From: Amanda Scholes on behalf of Planning.Responses
Sent: 18 January 2022 12:13
To: Planning Scanning
Subject: FW: Planning Consultation on: P/178/21/OUT

From: Laura Gibbons
Sent: 18 January 2022 12:08
To: Planning.Responses
Cc: Simon Davis
Subject: RE: Planning Consultation on: P/178/21/OUT

Engineers Comments on Flood Risk and Surface Water Drainage

Application No: P/178/21/OUT
Registered: 11th January 2022
Site Address: Land West of Pagham Road Pagham
Grid Reference: 489151 98966
Description of Works: Outline application with all matters reserved (except access) for the construction of up to 106 new homes, formation of access onto Pagham Road, new pedestrian and cycle links, the laying out of open space, new strategic landscaping, habitat creation, drainage features and associated ground works and infrastructure. This application is a Departure from the Development Plan and may affect the setting of a Listed Building.

Figure 6-1: EA Flood Zone Plan showing 1 in 100 & 1 in 1,000 year floodplains

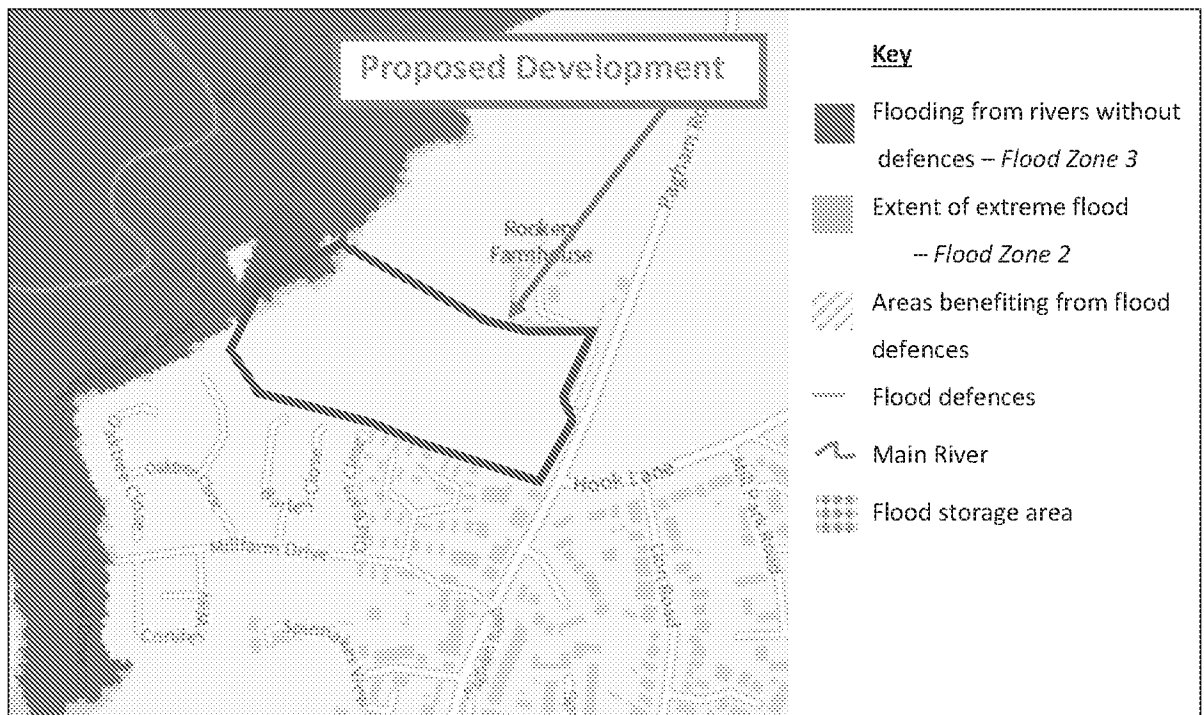
The application site includes an area within Flood Zone 3. The FRA should reference this, site specific flood extents should be determined based upon predicted flood elevations and topographic survey. Surface water drainage attenuation must not be located within areas at risk of flooding.
